3 February 2021
 Our Ref: 2517 / DPIE Ref: SSI-9487

RE: Submission in relation to the Inland Rail – Narromine to Narrabri (SSI-9487)

Prepared by:	Jim Lawler, Associate, Groundwork Plus Pty Ltd PO Box 1779, Milton BC QLD 4064 P: 07 3871 0411, M: 0406 680 969, E: jlawler@groundwork.com.au
On behalf of:	Regional Quarries Australia Pty Ltd
In relation to:	Inland Rail – Narromine to Narrabri (SSI-9487)
Submission:	Objection
Reasons:	<ol style="list-style-type: none"> 1. Chapter C3 of the N2N EIS identifies exceedances of noise, vibration and air quality criteria for the operation of the borrow pits which would not ordinarily be acceptable for an Extractive industry. 2. The N2N EIS has not considered whether dust from the resource at the borrow pits could result in a human health risk for respirable crystalline silica. 3. The borrow pits for the N2N should be held to the same assessment criteria and operational obligations as a commercial quarry operation. 4. The N2N has not considered the most likely haulage routes for quarry materials from existing quarries in Dubbo and should be revised to include an assessment of impacts of construction traffic on the Mitchell Highway, Tantitha Roa

Figure C3.11 Air quality impacted receivers – borrow pit C (Euromedah Road, Narromine)

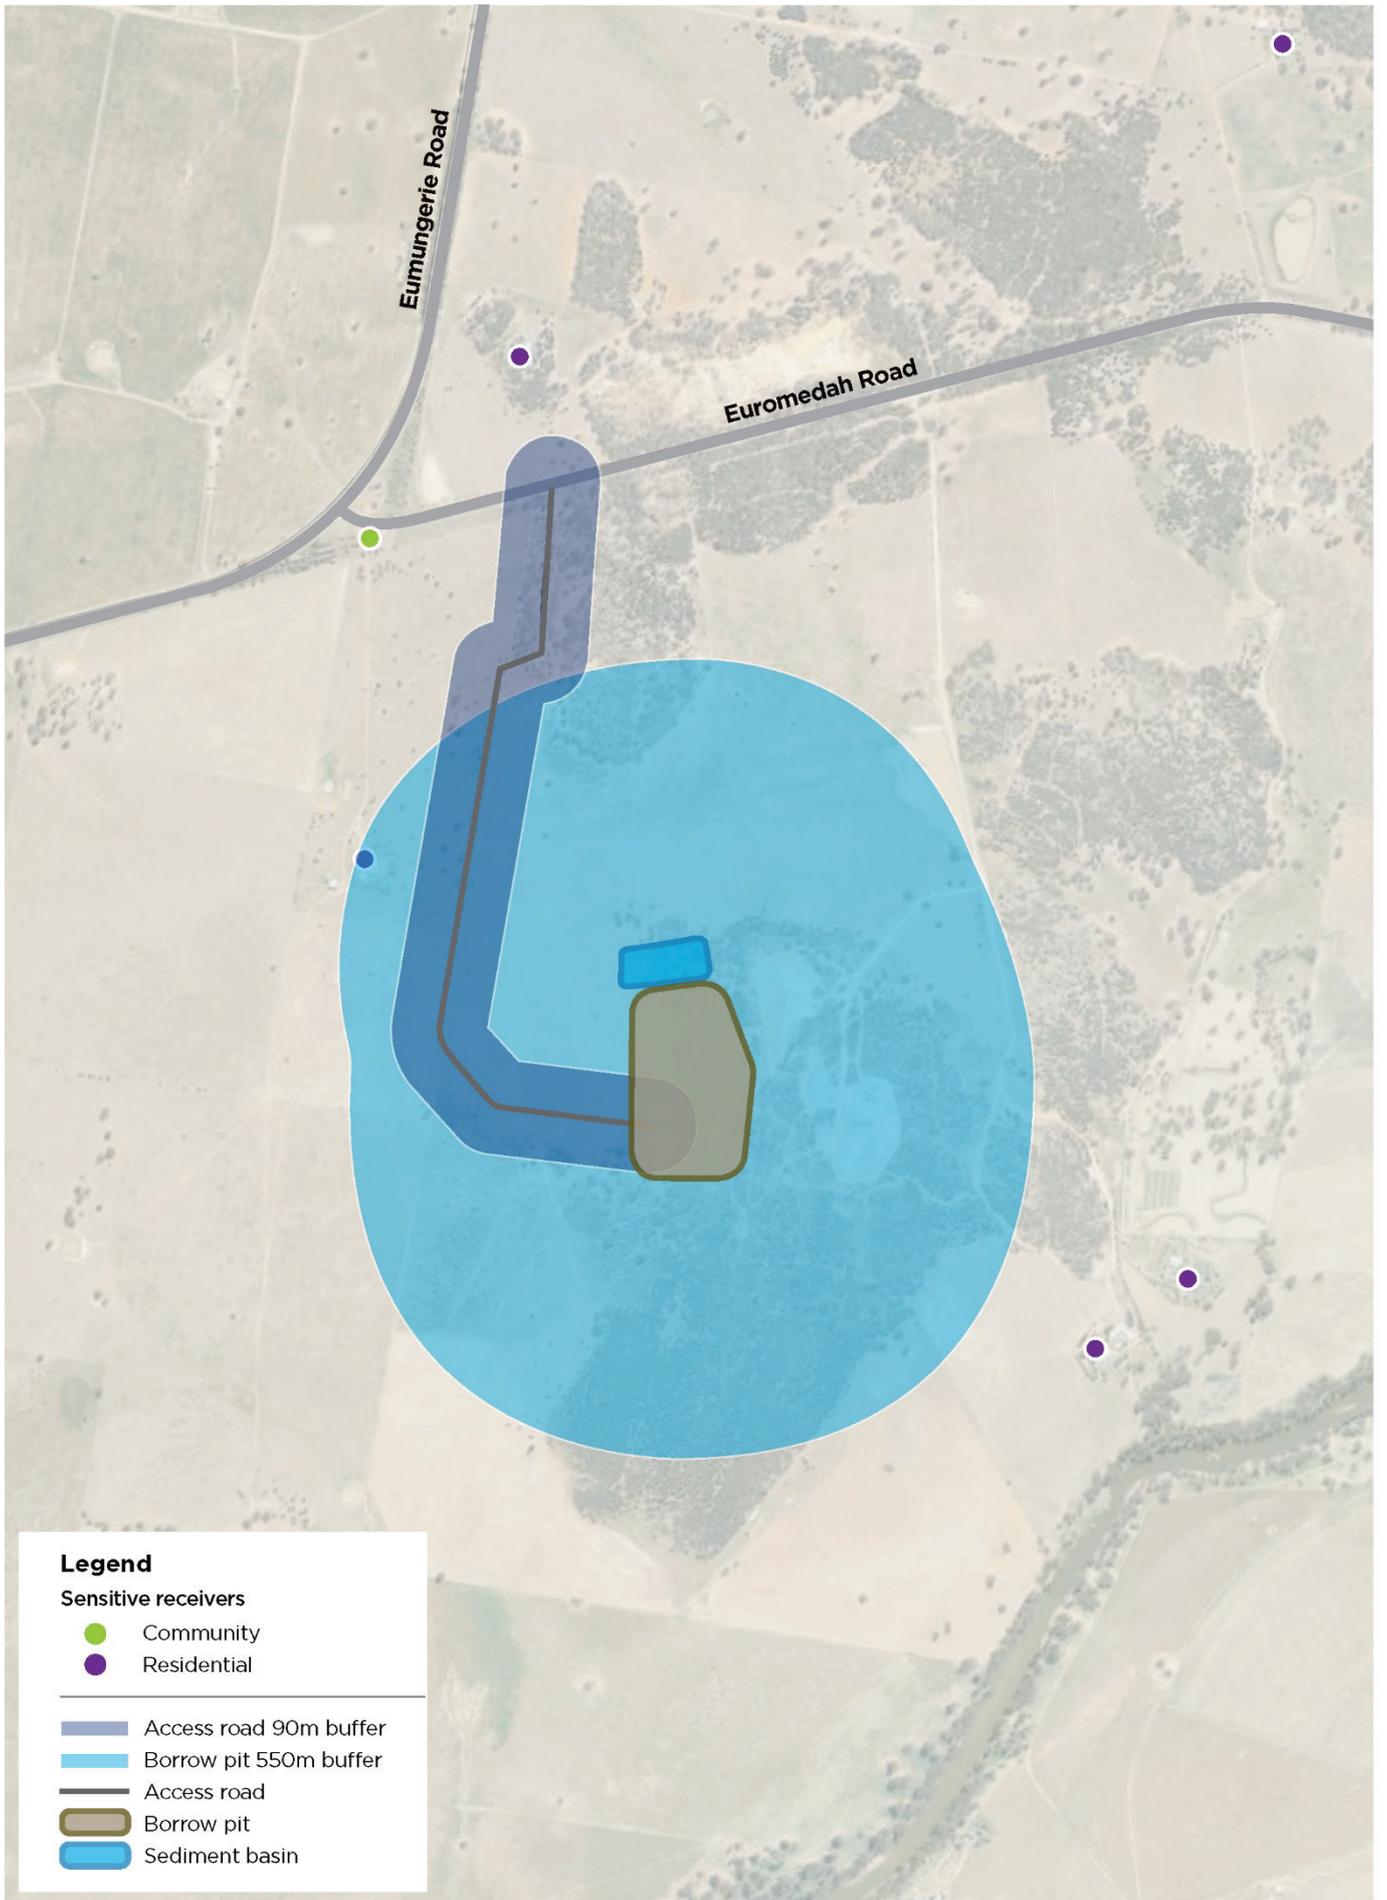
As shown in Table C3.9, during the use of the borrow pits, exceedances of the relevant air quality criteria are predicted at one sensitive receiver near borrow pit C.

Section 3.1.2 of the N2N EIS identifies that, 'there is a low risk of naturally occurring asbestos or acid sulfate rock' but does not clarify if the resource at the borrow pits contains material which could result in potential risk of respirable crystalline silica in dust emissions. This is particularly relevant for Borrow pit C which is predicted to result in an exceedance of the relevant air quality criteria.
